Landscape Plan.pdf Markup Summary

DRAWING NO.  
1 of 2  
FINAL LANDSCAPE PLAN

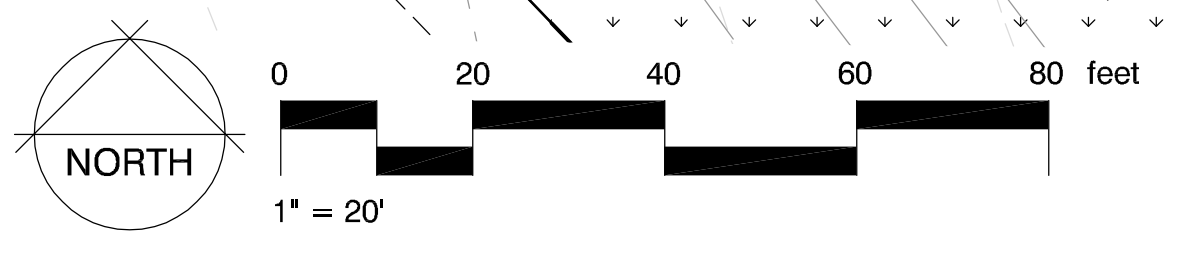
Should show entire lot and indicate where close up is located

Landscaping per PUD is 1/30'
